3. SIGNAGE

City of Sydney Comment - 3 a)

FIGURE 19 HICKSON ROAD ELEVATION EXISTING AT PIER 2/3

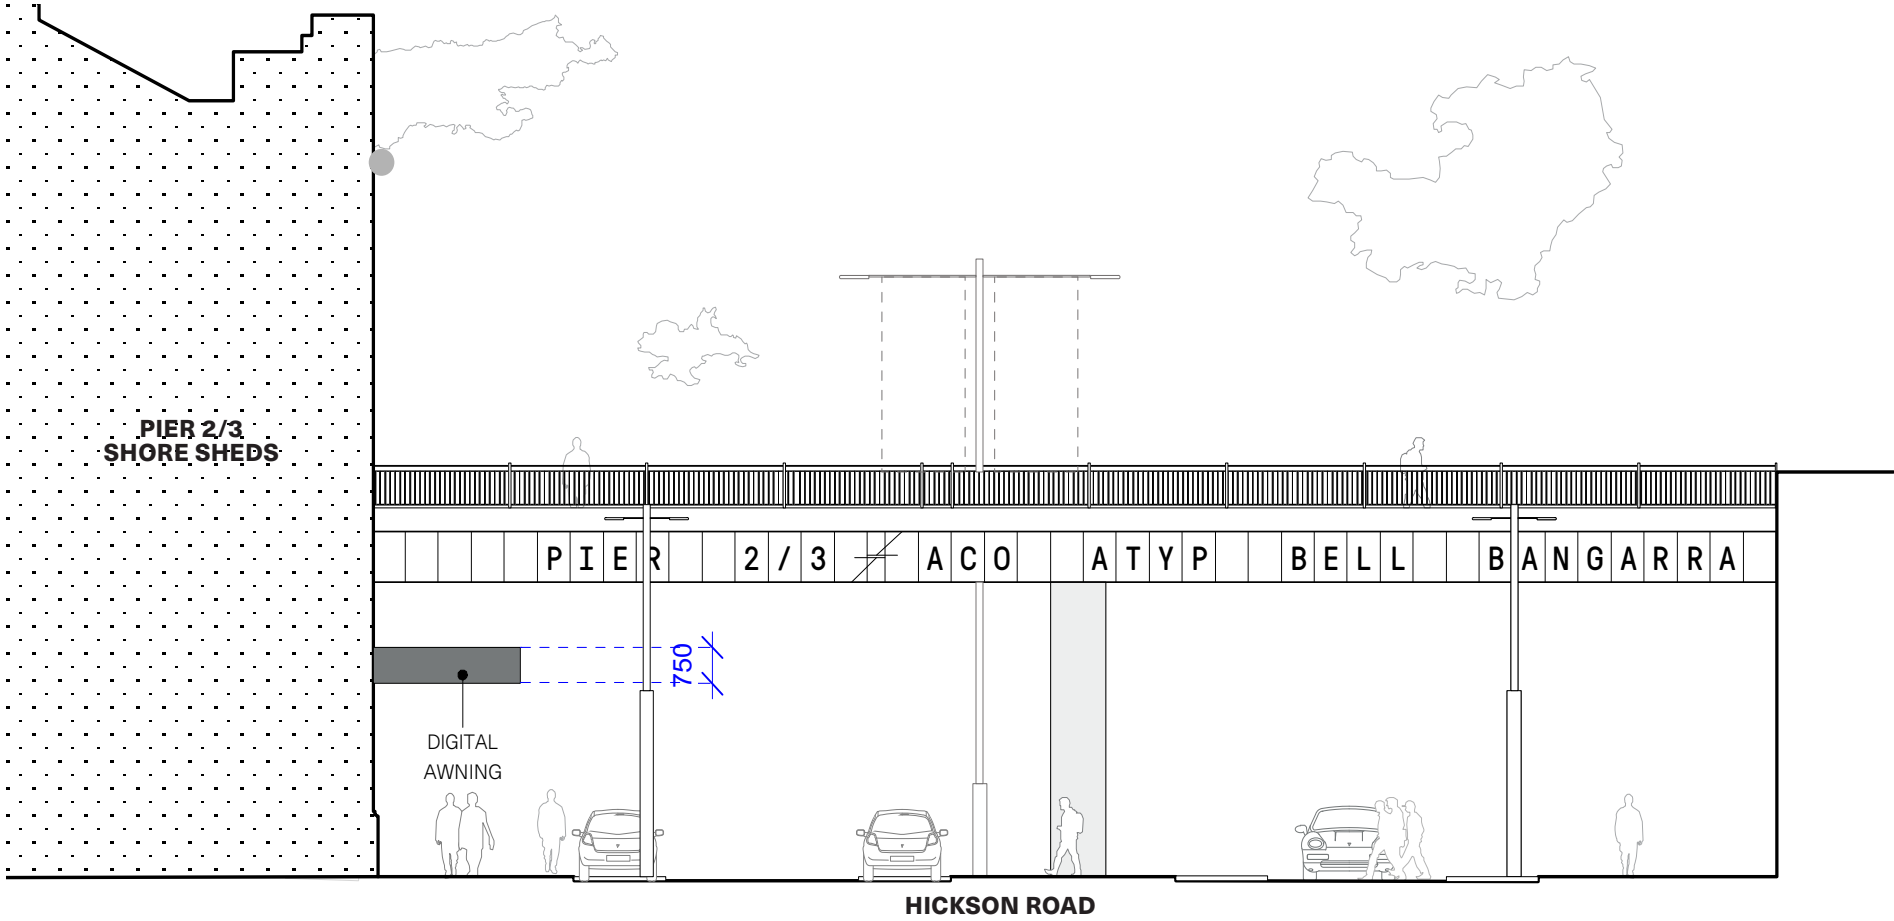
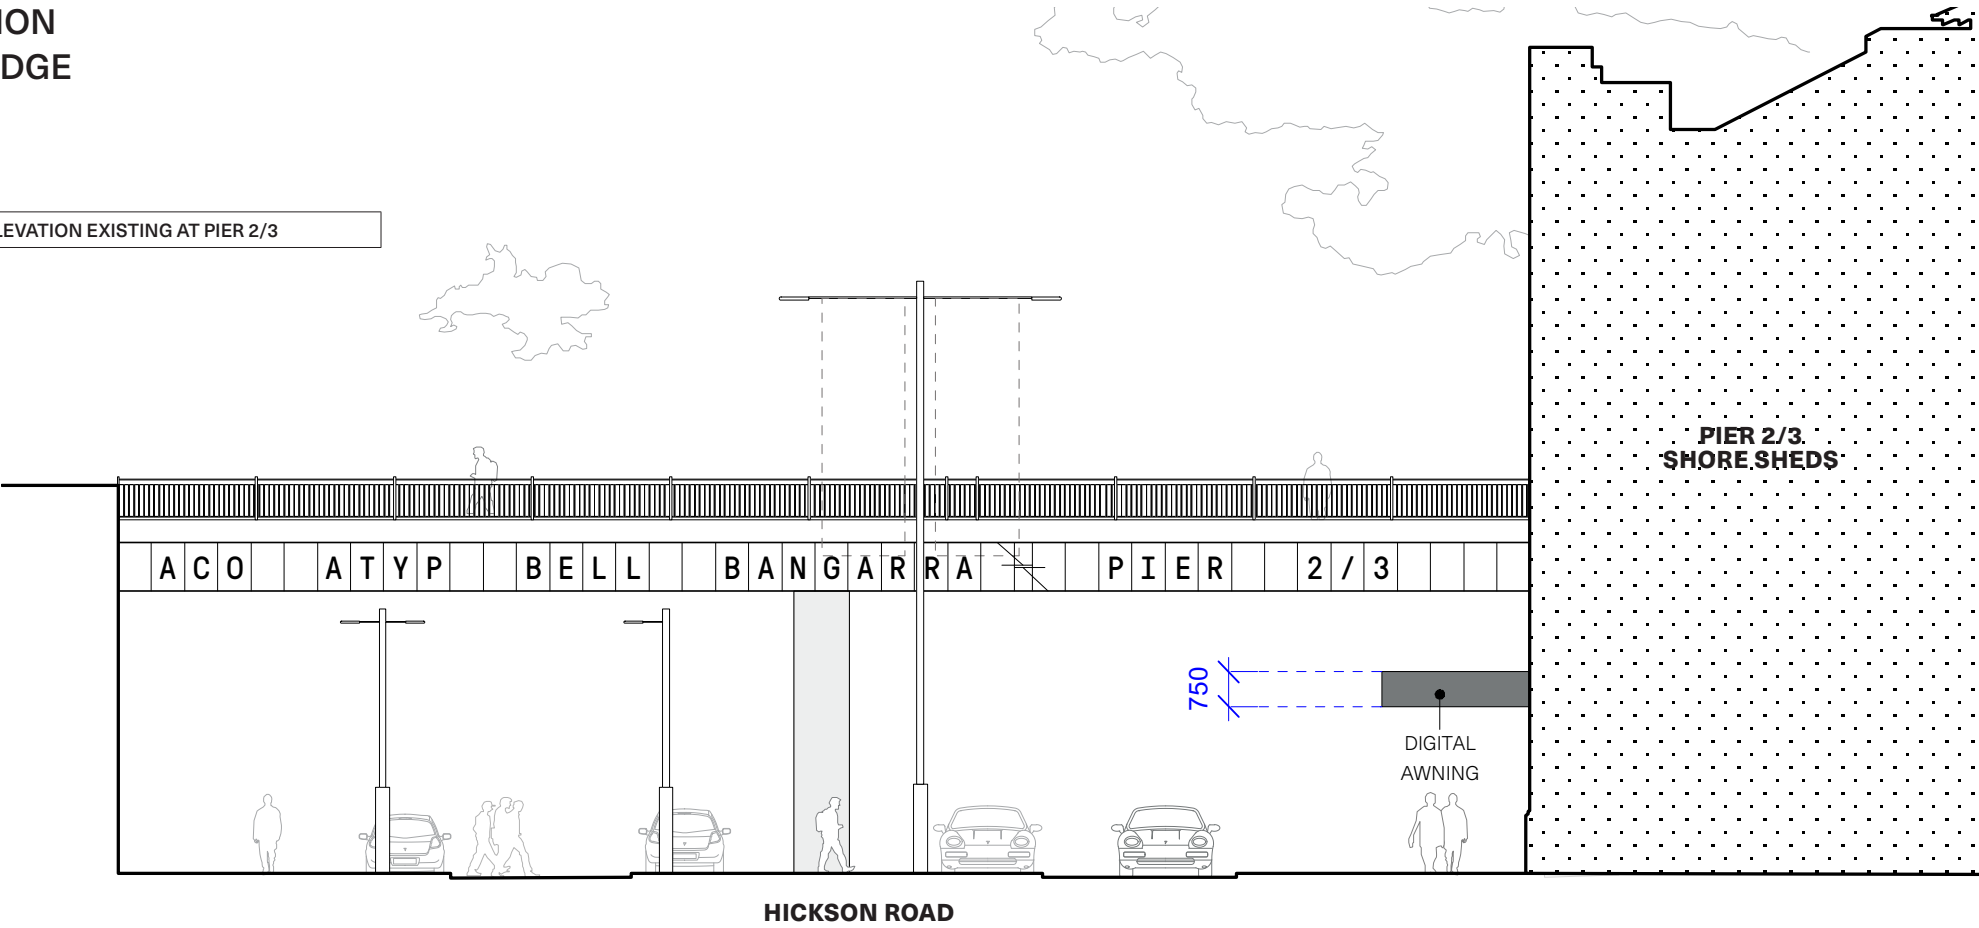
The proposed digital awning signs as shown in Figures 12 and 13 indicate they have a minimal projection however, Figures 19 and 20 show them as substantial projecting awnings, though dimensions are not annotated. The awnings should be sized to allow a margin around them, enabling a reading of the rendered surface on which they are affixed. They should be set in from each side by approximately 200mm for the same reason.

Figures 19 and 20 illustrate signage across the viaduct bridges akin to "The Goods Line" signage. This is supported for the 'Pier 2/3' and 'Wharf 4/5' signs as these are place based signs, as is The Goods Line sign. There is some concern that the other proposed bridge signs are for dance/theatre companies that may come and go to the precinct. The signage strategy should speak to the removal / replacement of these signs. The signage is designed for the present number of companies, with particular name lengths. Removal of parts of the sign over time due to the loss of a company should be addressed.

The Applicant will develop the detailed design of the signage and wayfinding in consultation with the Heritage Council and City of Sydney. This will include consultation in relation to the sizing of the awnings. The Applicant commits to ensuring that the awnings will be designed to enable a reading of the rendered surface to which they are affixed.

The Applicant confirms that there will only be place based signage on these structures.

FIGURE 27 STATUTORY SIGNAGE LOCATIONS

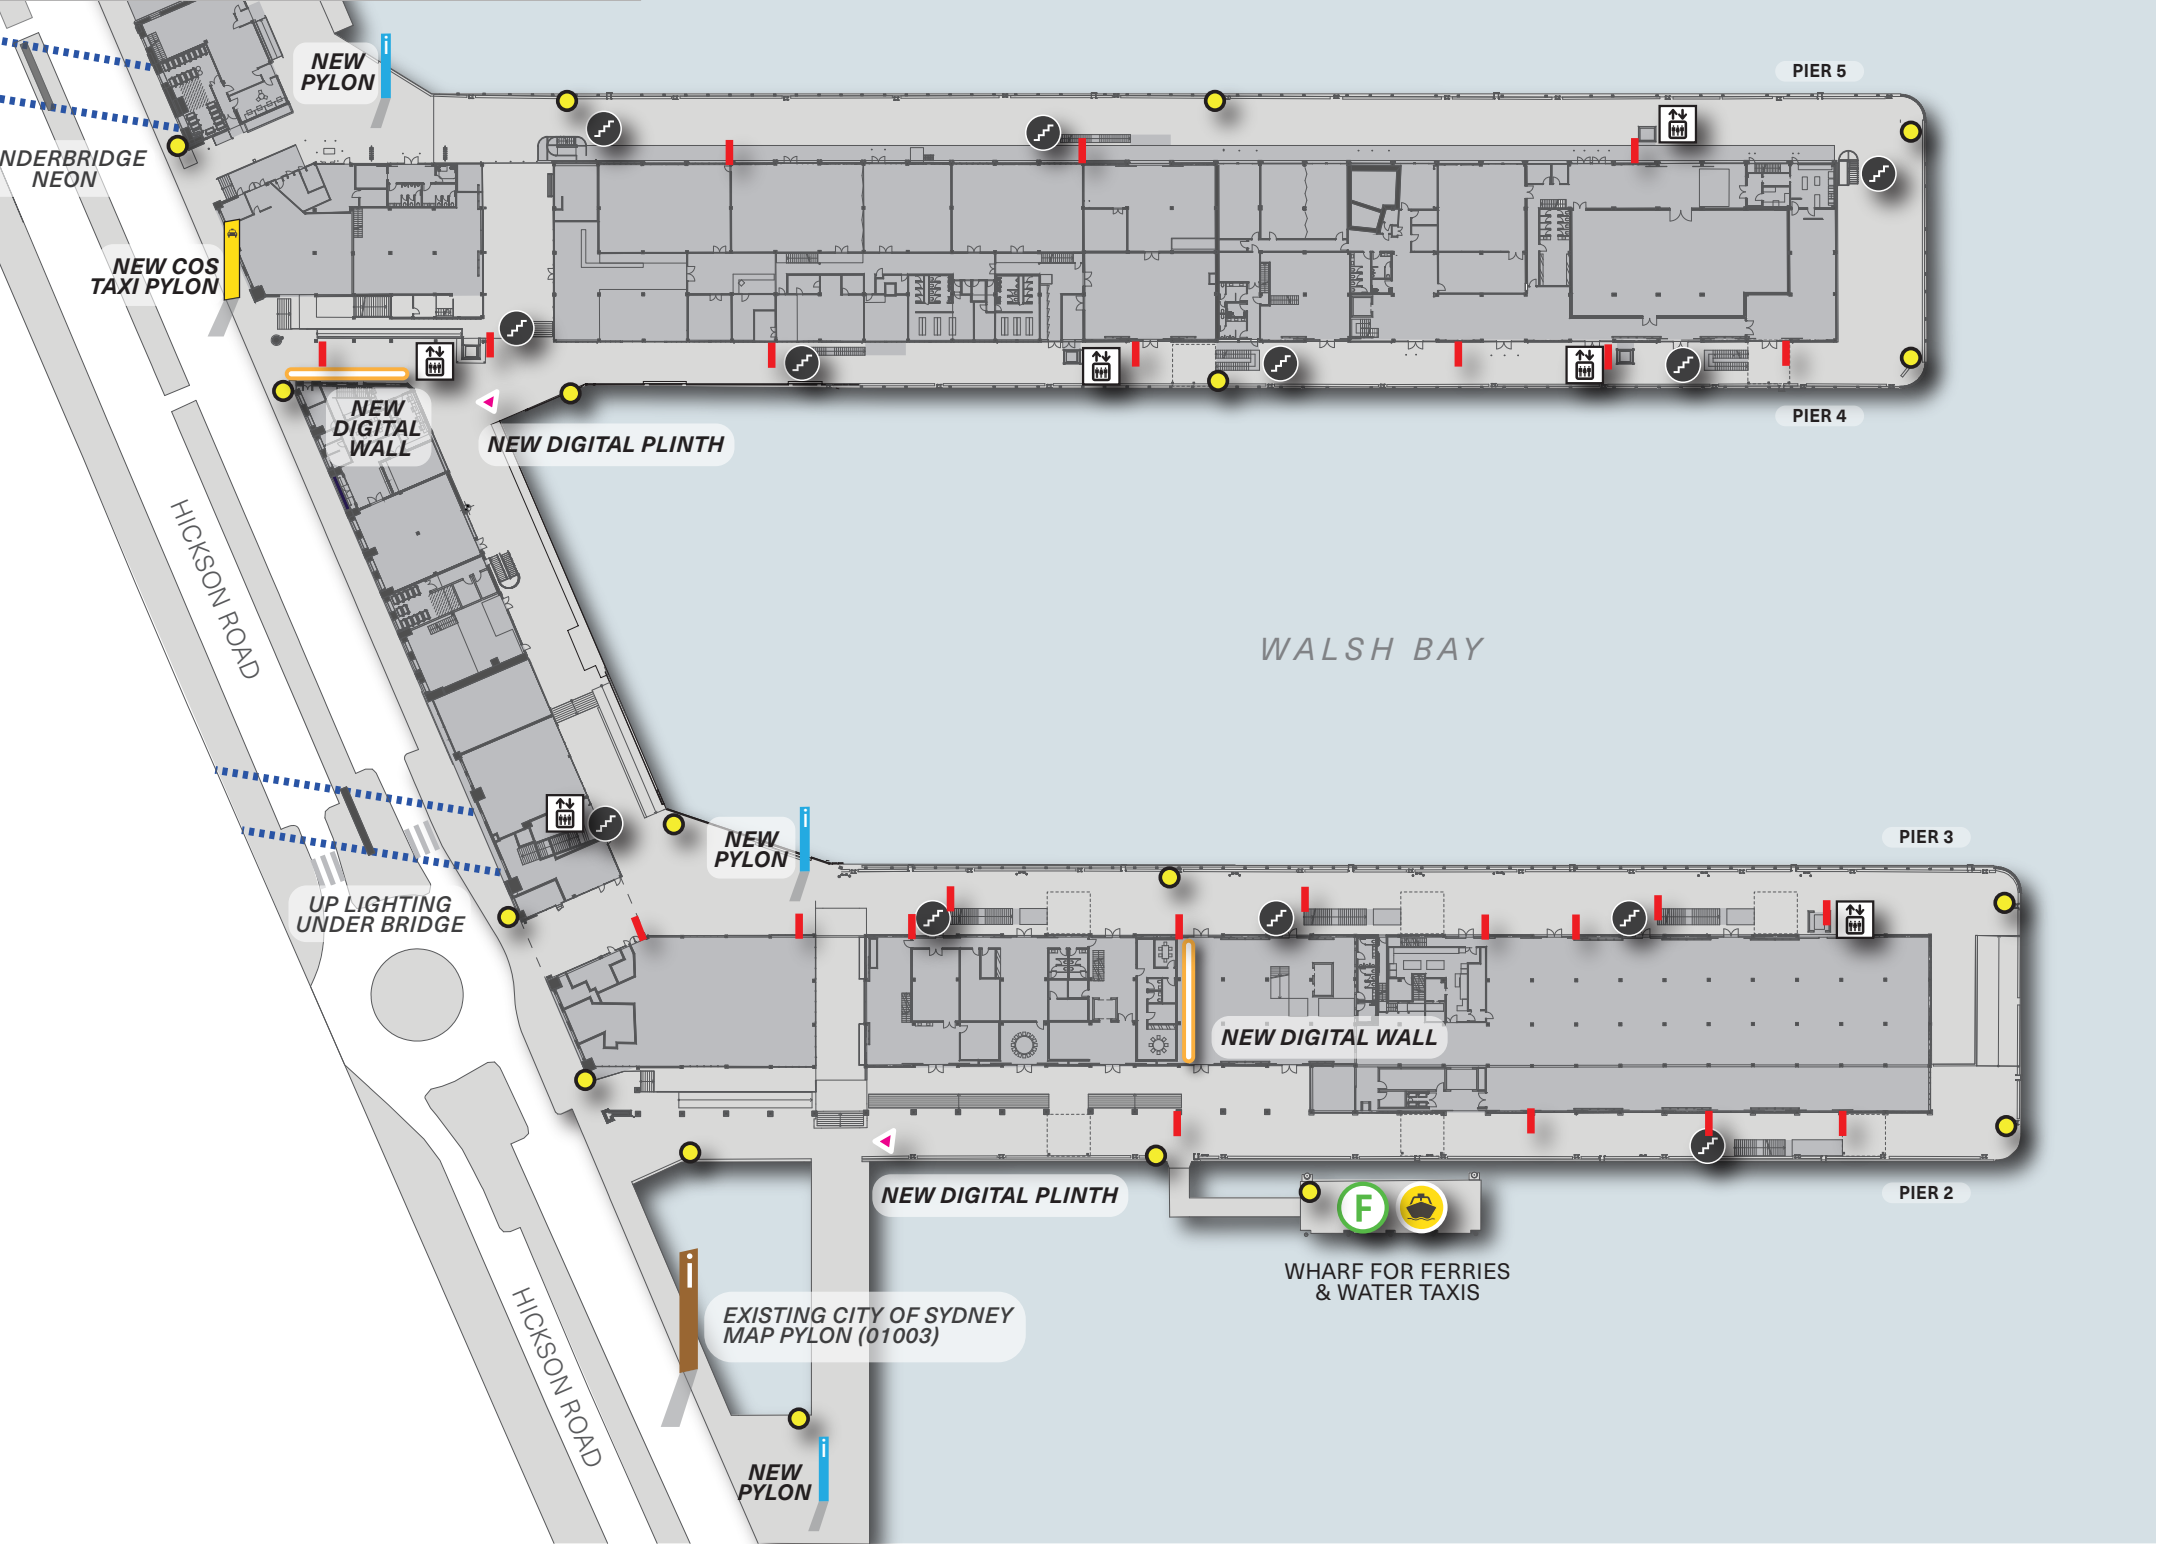
Details of the new proposed signs shown in Figure 27 (red lines marked as “signage location”) are unclear. There are a substantial number of these signs and there is a potential for clutter depending on the purpose, size, design and location of these signs.

No details of the 'new digital walls' included in Figure 27 are provided. Details such as the size of these elements as well as their fixings to the wharf building fabric are required. Fixings should avoid significant heritage fabric and be reversible.

A revised signage plan is included on the following page, rationalising the number of tenant identification signs internal to the Precinct. The proposed signage locations and sizes are shown on the plan overleaf and the perspectives adjacent. The signs have been sized to relate to the original fabric of the wharves and are indicated in red for clarity, with the proposed digital walls marked orange.

New 'digital walls' are proposed in the Shoreshed 4/5 Breezeway 1, adjacent the Visitor Portal and on the southern wall of the Pier 2/3 Colonnade. The final size of these digital elements will be developed in detailed design in consultation with the City of Sydney and Heritage Council, however, Figures 16 and 17 to the right indicate the areas where digital walls are proposed and the design intent. The fixings will be developed in a manner to minimise any impacts on heritage fabric and be reversible.
